Response to ISH4 and ISH5 Action Points

This document provides Cambridgeshire County Council (**CCC**) and Fenland District Council's (**FDC**) (together, **the Councils'**) responses to the Action Points addressed to CCC and/or FDC arising from the Issue Specific Hearing 4 (ISH4) held on 17th May 2023 and the Issue Specific Hearing 5 (ISH5) held on 18th May 2023, with regards to the Medworth Energy from Waste (EfW) Combined Heat and Power (CHP) Facility.

**Figure 10.1i**  
**New Bridge Lane access design**

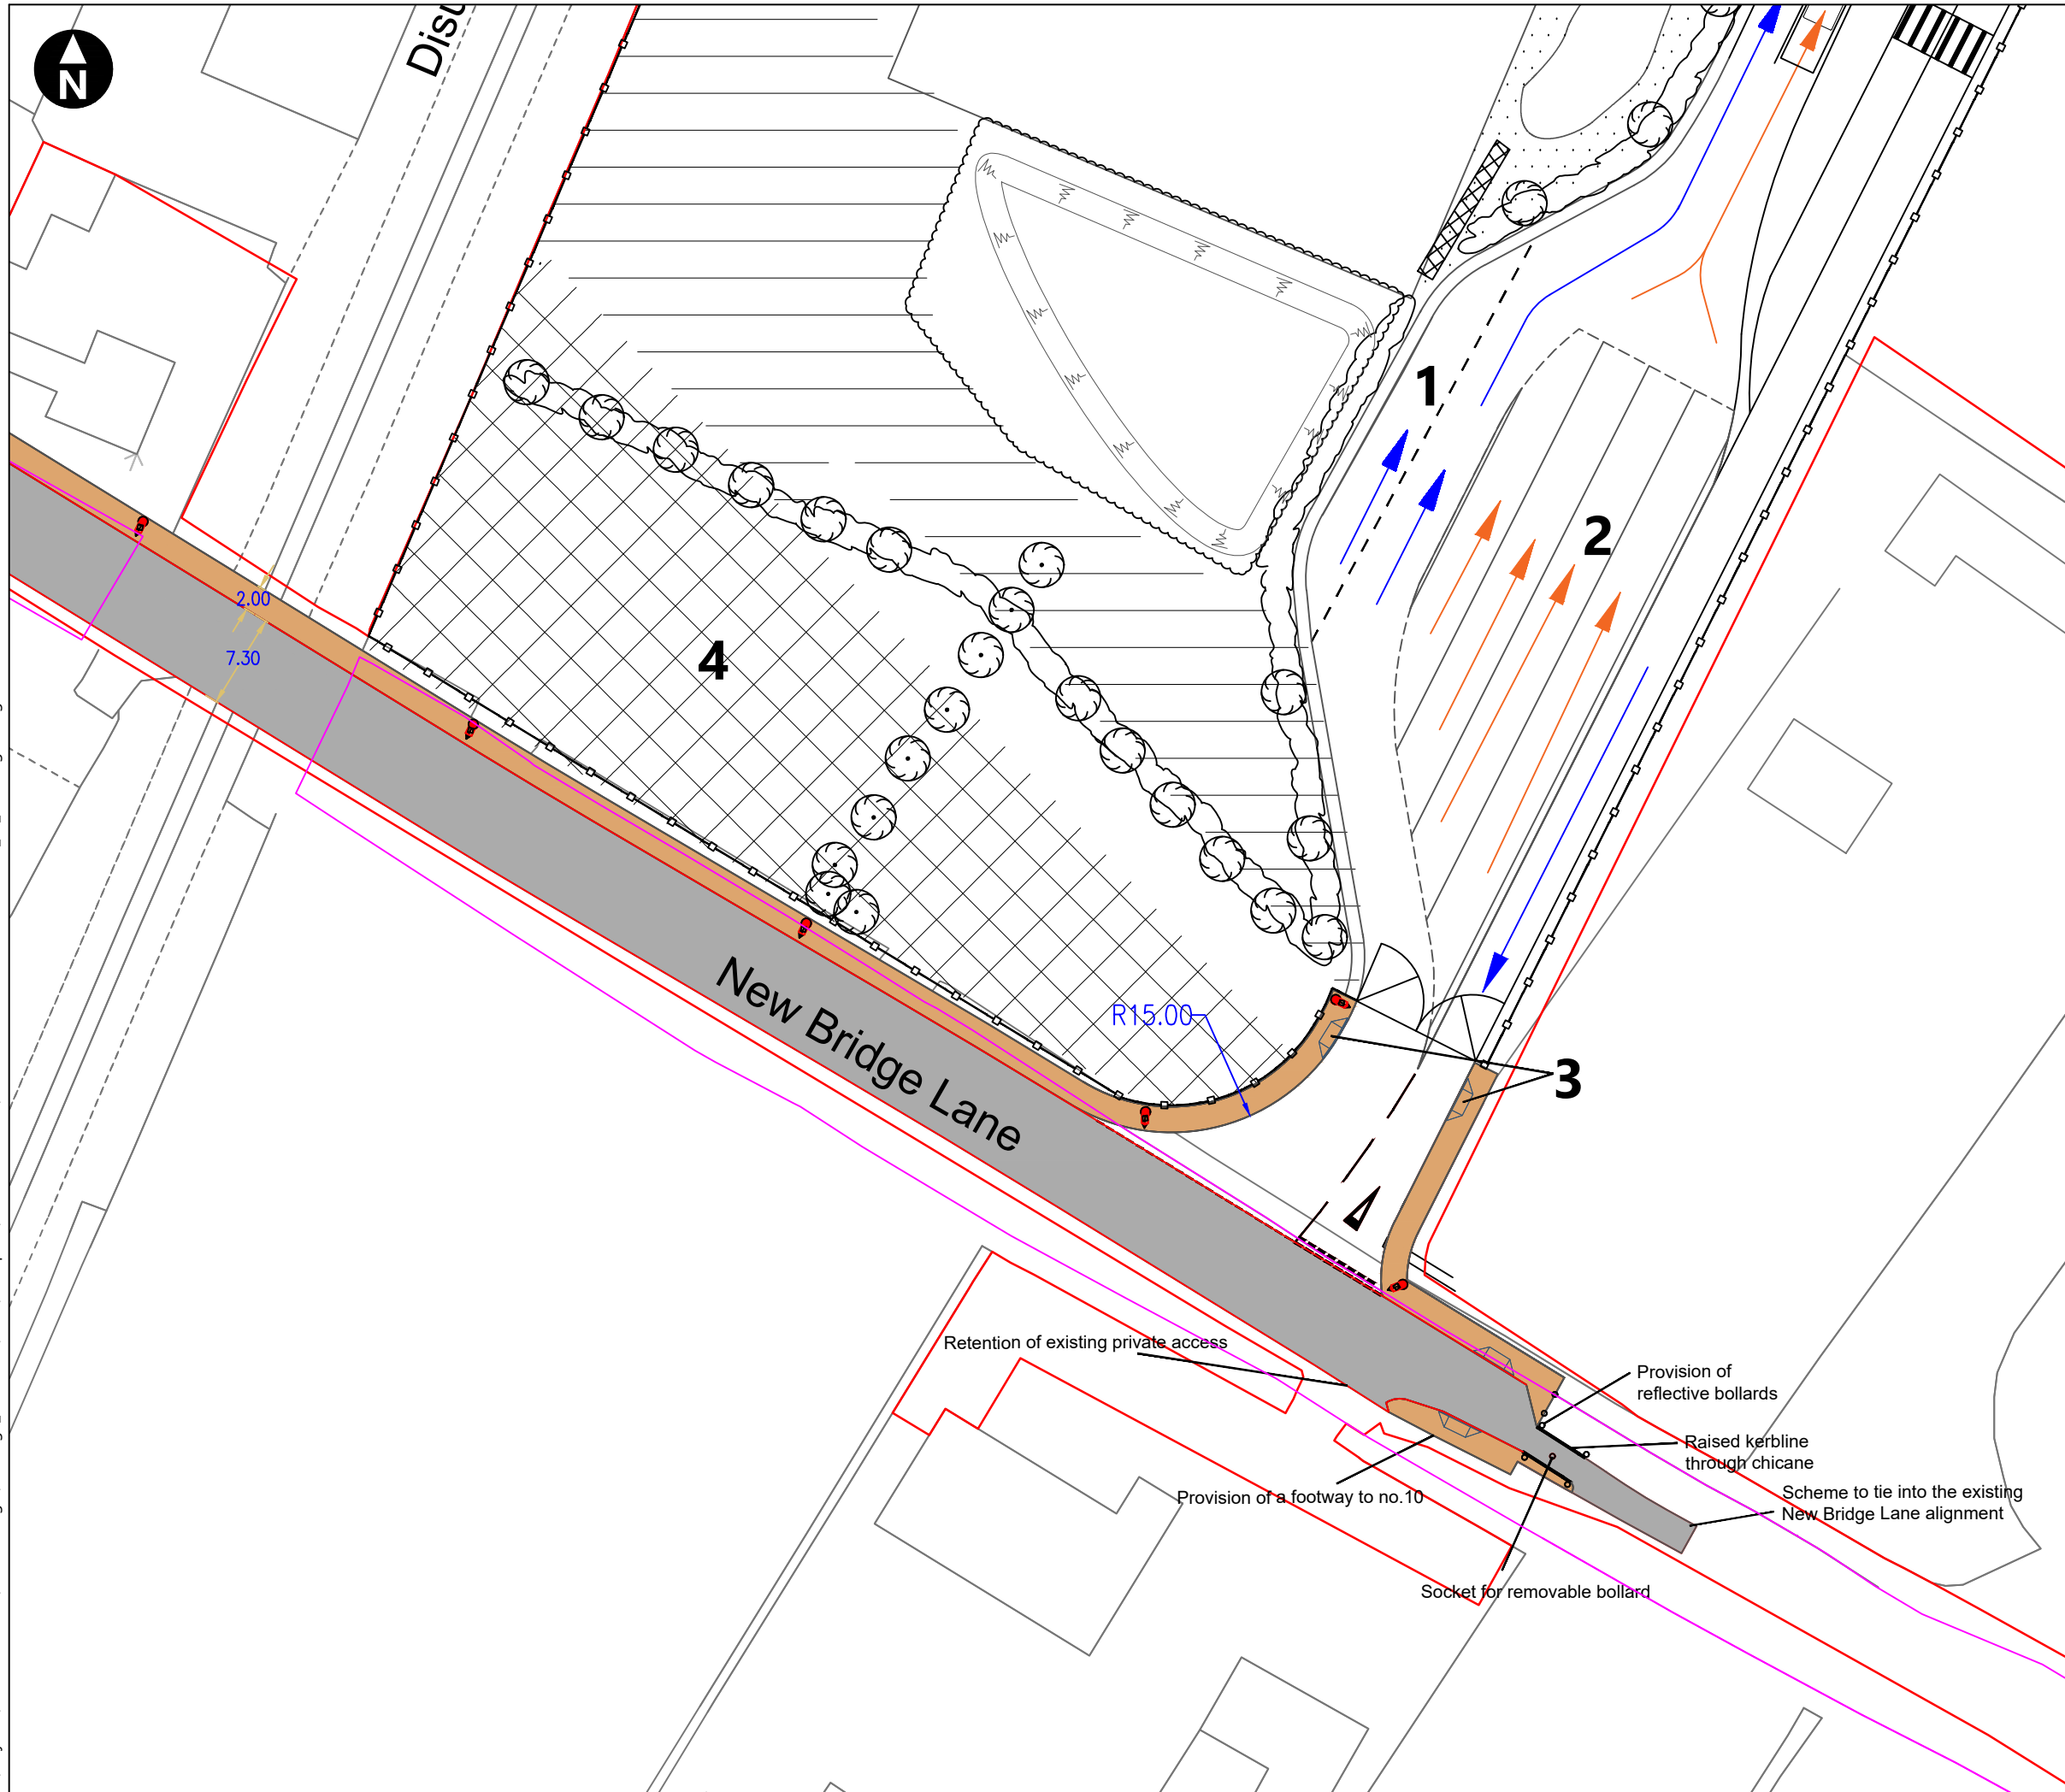
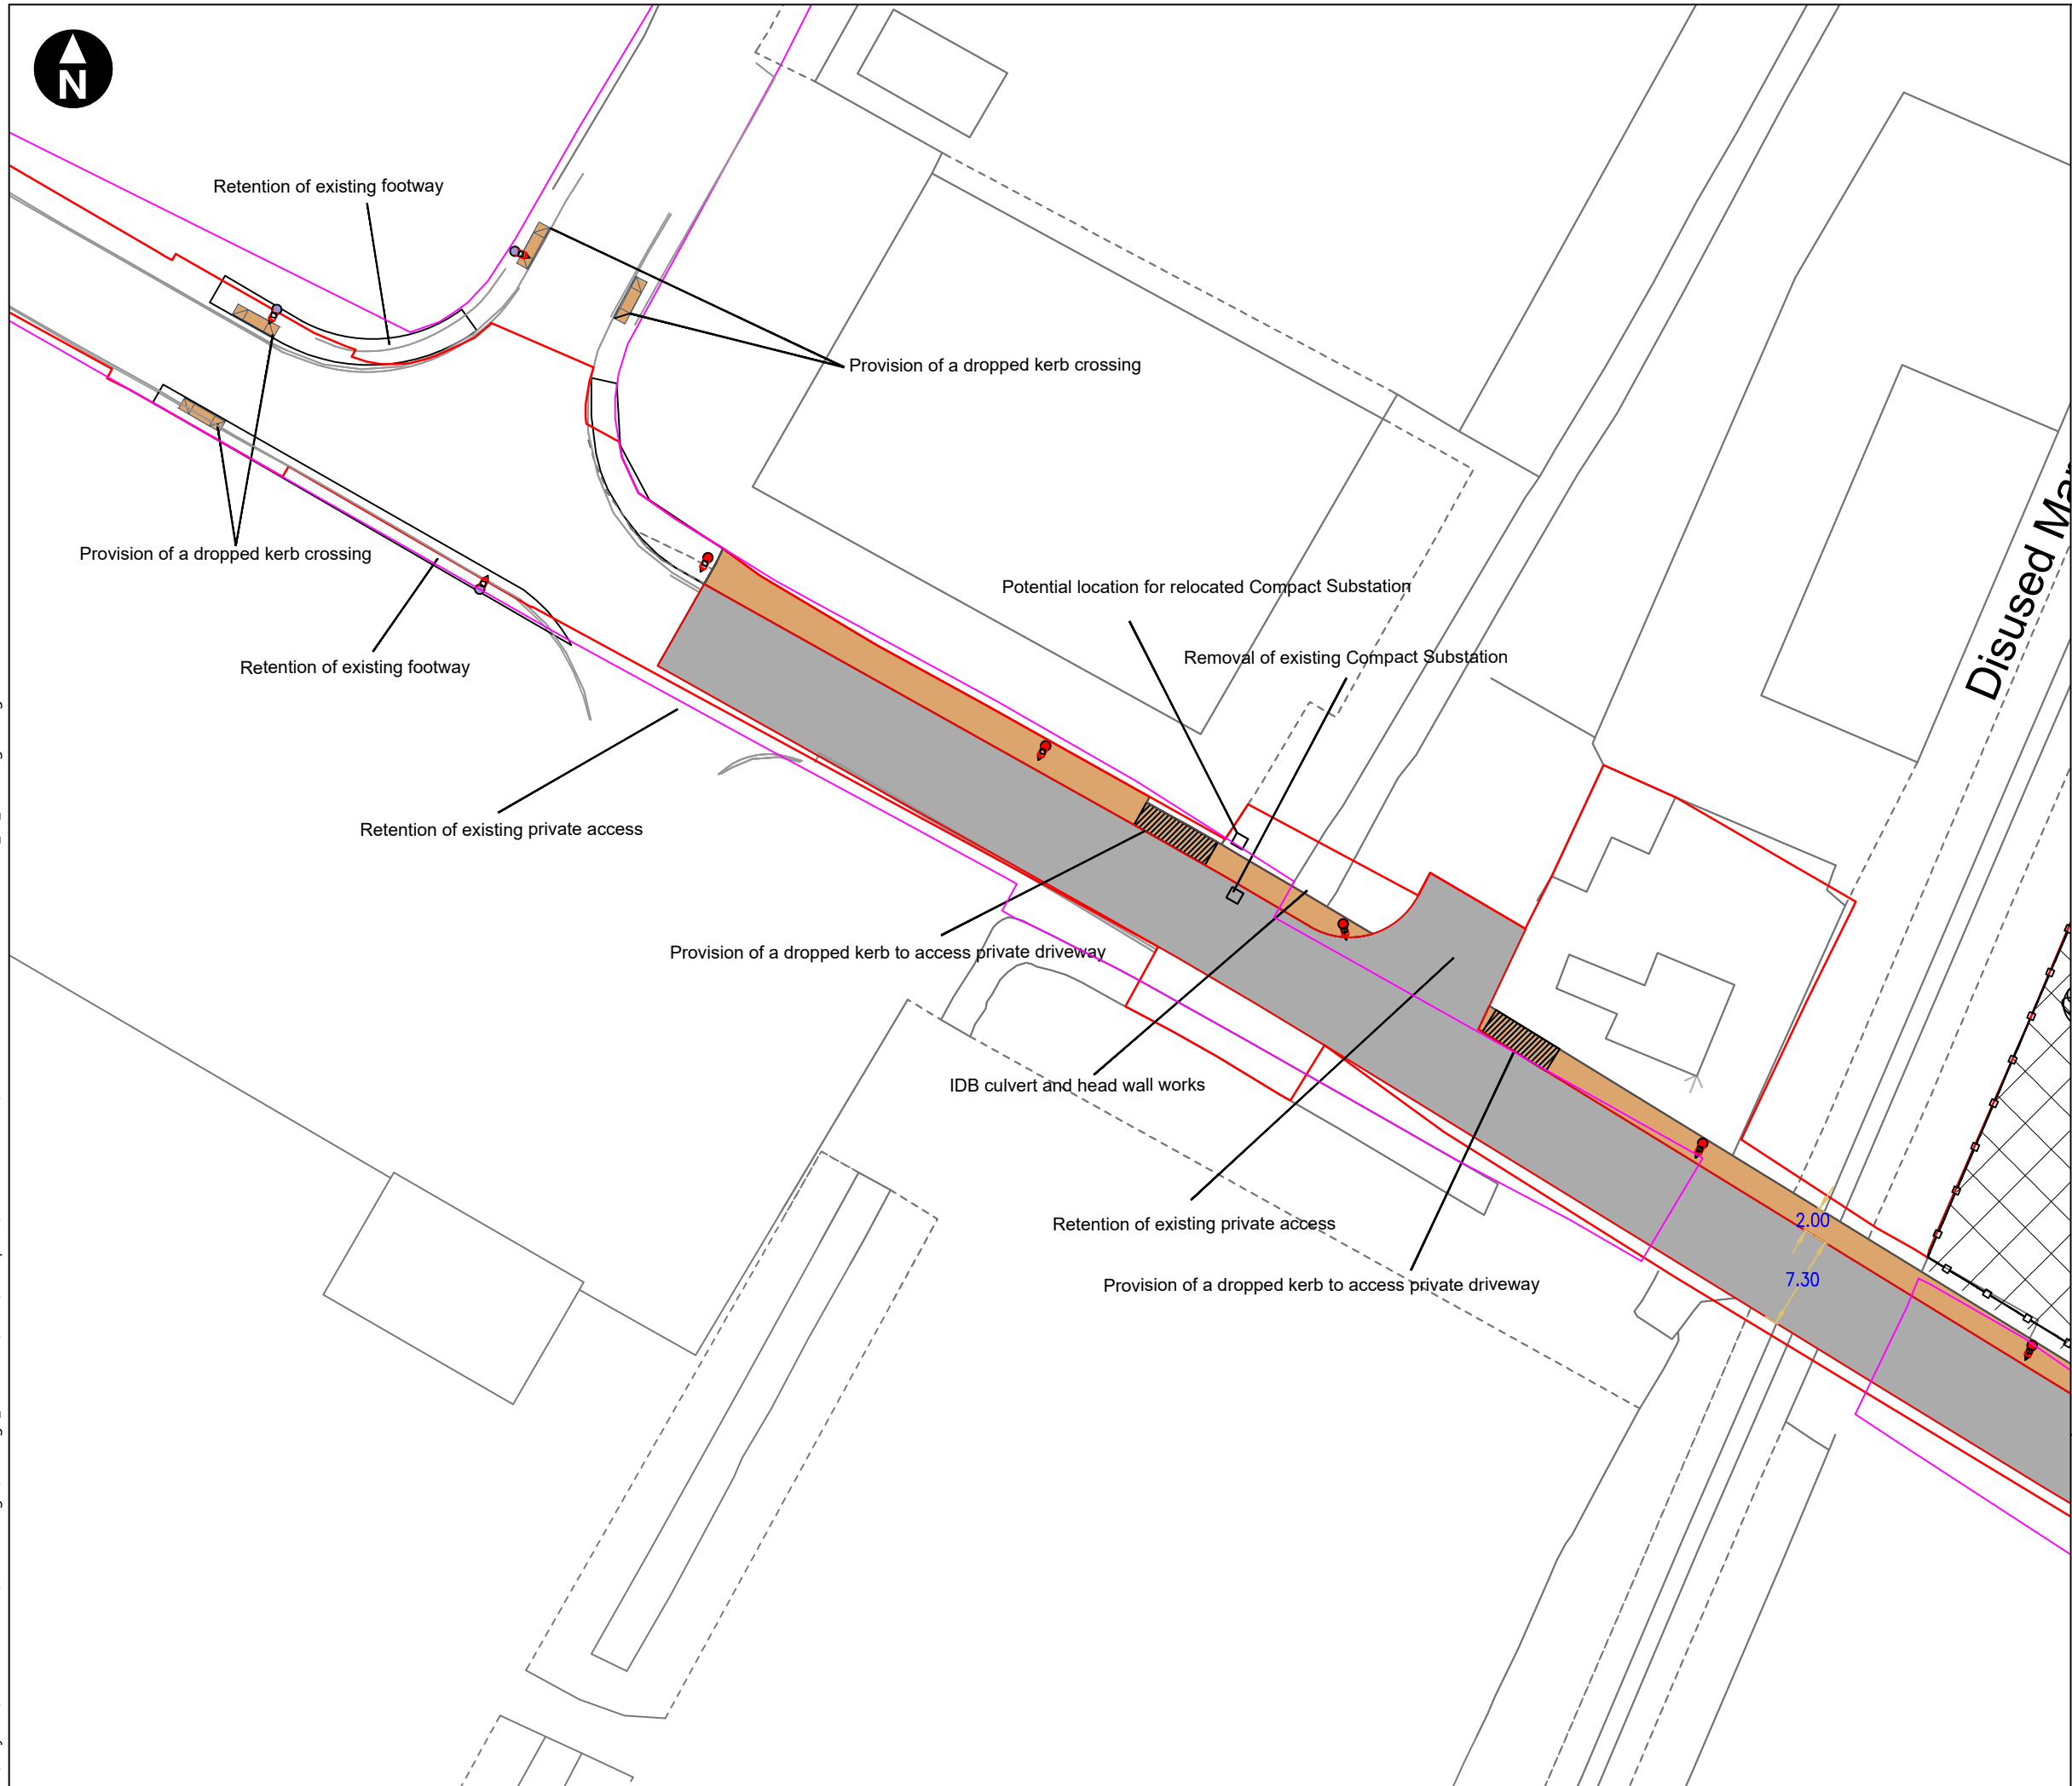
Action No.	Party	Action	Deadline	Response
2	Applicant Cambs CC	Applicant and CCC to engage on outstanding issues in relation to Highways issues – including Protective Provisions, particularly payments for highway damage, and to update ExA and SoCG to reflect this.	Deadline 5	<p>The Applicant has engaged CCC on the following matters:</p> <ul style="list-style-type: none"> • Draft Heads of Terms for a Section 278 agreement (Highways Act 1980) for works within the highway. CCC returned its comments to the Applicant on 31 May 2023. The Applicant provided CCC with an updated draft S106 heads of terms on 13 June 2023. CCC are currently reviewing the proposed head of terms and will provide feedback to the Applicant accordingly. • Draft Protective Provisions proposed for inclusion in the DCO. CCC's consideration of the Applicant's first draft is ongoing. • Design of highway works affecting New Bridge Lane, and the proposed pipe bridge over Weasenham Lane.
